TOWN OF MONUMENT - WATERLINE AND STORAGE TANK SITE DEVELOPMENT PLANS LOT 6, FOREST VIEW ESTATES FILING NO. 4

PCD FILE NO. **PDR-21-030**

PROJECT NO.	04-20-0153	BY	DATE
	DRAWN	S. CALE	REVISIONS	
	DESIGNED	J. ADAMS	NO.	
	APPROVED	J. ADAMS	This document or any part thereof in detail or design shall not be used for any project without the written authorization of Forsgren Associates Inc.	
PROJECT NO.		56 INVERNESS DRIVE EAST #112, ENGLEWOOD, CO 80112		PH: 720.232.6644
2.0M GALLON TANK GRADING AND EROSION CONTROL PLAN		SHEET NO. 1		
DATE:		JAN, 2022		
PAGE NO.:

TANK SITE PLAN
SCALE: 1"= 20'

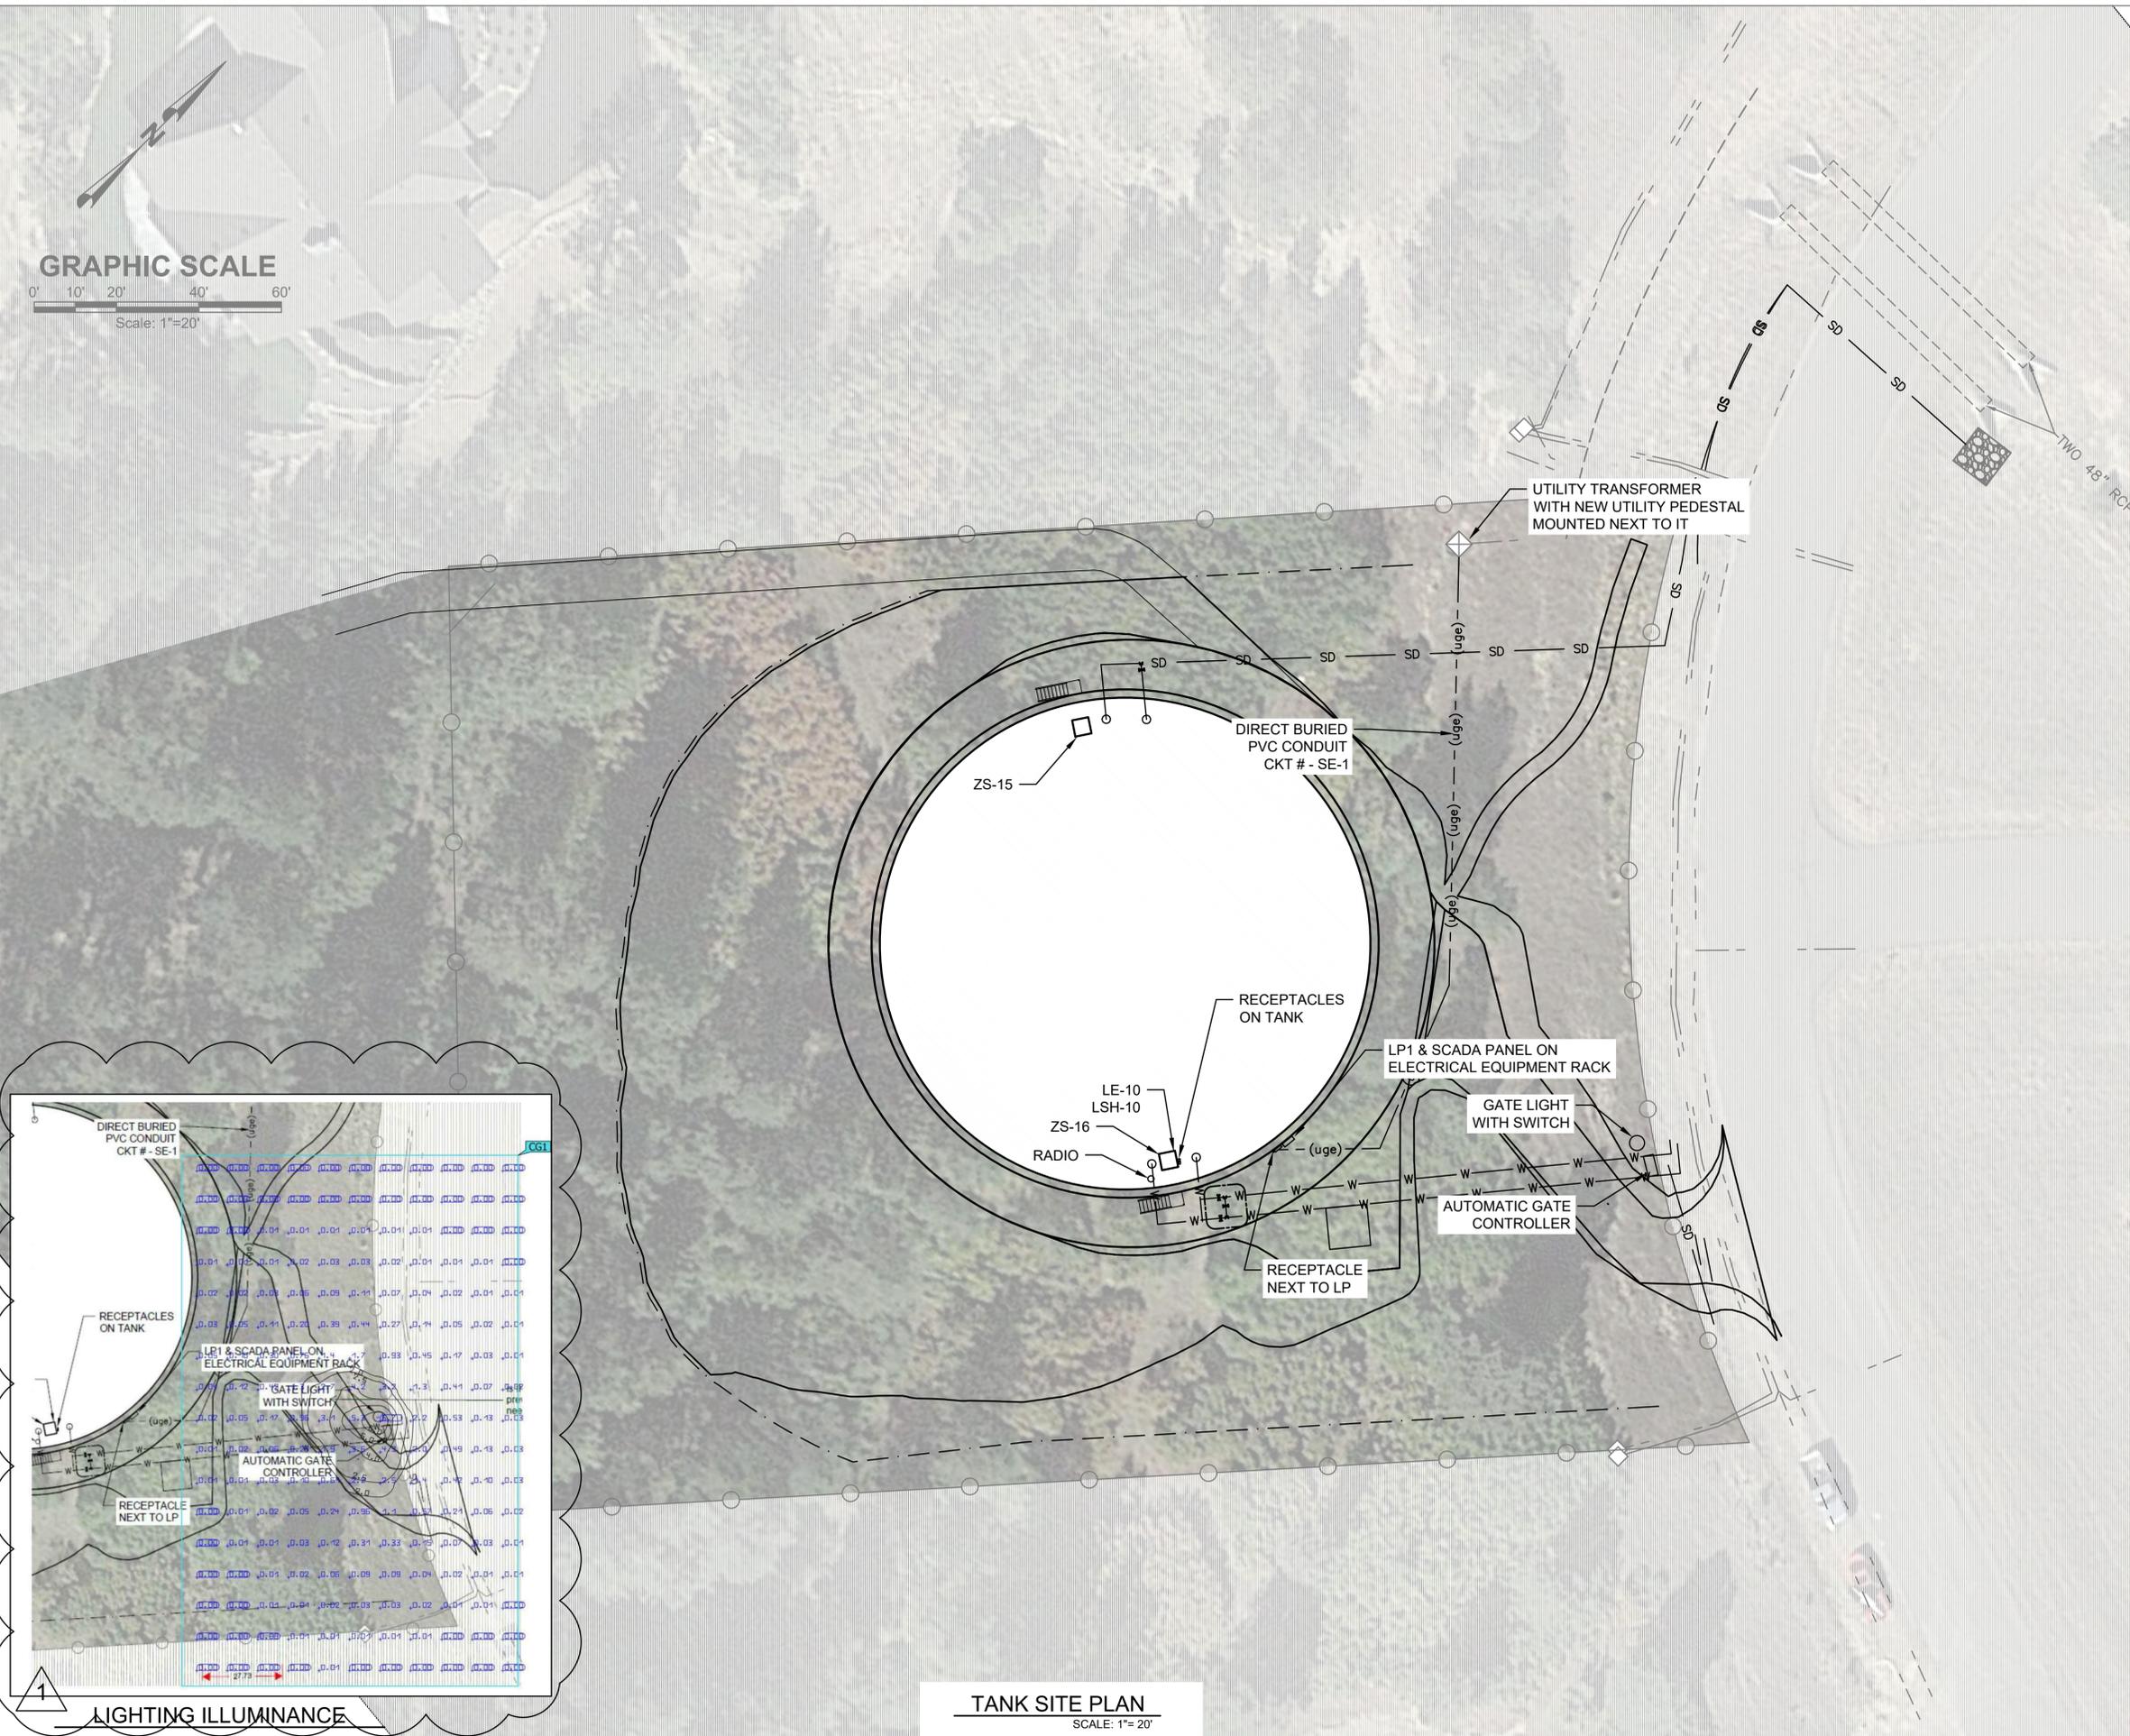
Unresolved comment from Review 1:
Items H and M. If "limits of disturbance" and "construction boundary" are the same, change to "limits of construction/disturbance" or otherwise show as separate linetypes for each on the legend and figure.

There is soil disturbance involved with installation and maintenance of SF. Revise drawing to show LOC outside of SF. I know that the layout of BMPs is graphical in nature and that the LOC and SF are likely to have the same perimeter. But since the area of soil disturbance is so close to 1ac, it would be good to show a more exact LOC. The current outline of the SF shows the soil disturbance as 1.02ac.

Unresolved comments from Review 1:
- Checklist item "i" - make note of existing condition of vegetation (type of vegetation and estimated % coverage)
- Checklist item "p" - label/delineate areas of cut/fill (a note would be acceptable too, for example: "site is predominately cut on the southern half and...")

Is this gray shading supposed to also have the rock hatching? The gray shading is not shown in the legend. And the rock hatching needs to be 75ft min length per detail on next sheet. Revise both as needed.

GEC Plan must include entire length of pipeline (at an acceptable scale per item C on the checklist) to show seeding and mulching along the line, inlet protection, check dams in the roadside ditch, etc. This is standard for all UG utility projects like this. And address these BMPs associated with the pipeline in the SWMP text.
